Your ref:
Our ref: 23/02034/F
Please ask for: Lynn-Marie Elliott
Direct dial:
E-mail: borough.planning@west-norfolk.gov.uk

Details: **Replace existing sash windows. at West Croft 27 Crown Street Methwold
Thetford Norfolk**

I have received a planning application as detailed above but cannot process it until I receive some more information:

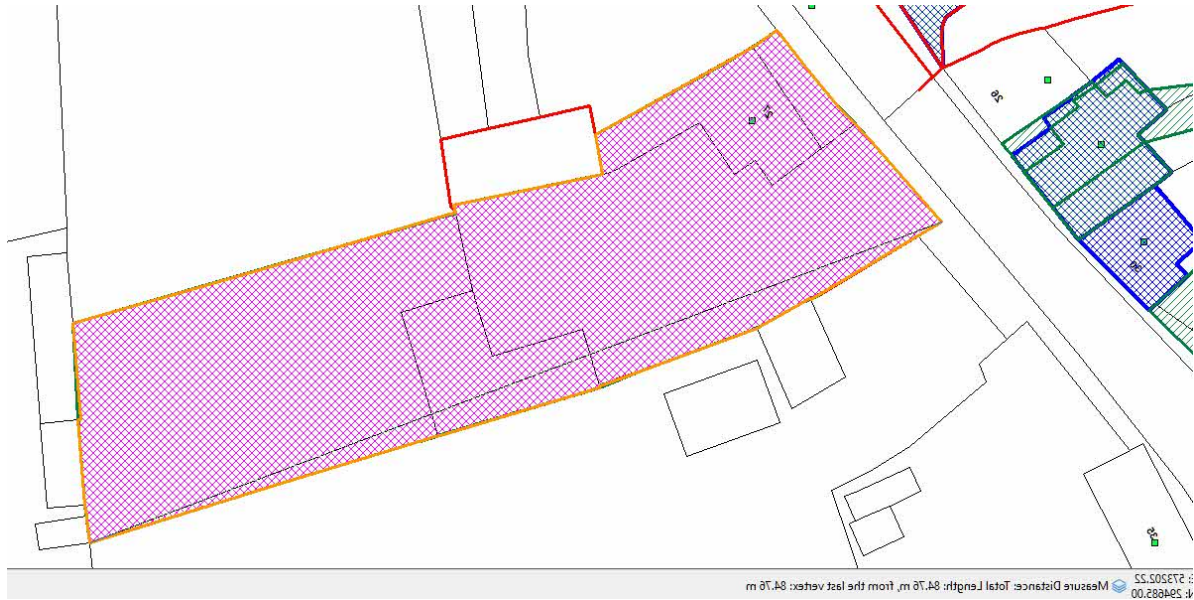
1. We do require the location plan to be to scale as all drawings must be drawn true to the stated scale. Please check and amend the measurements of the location plan.
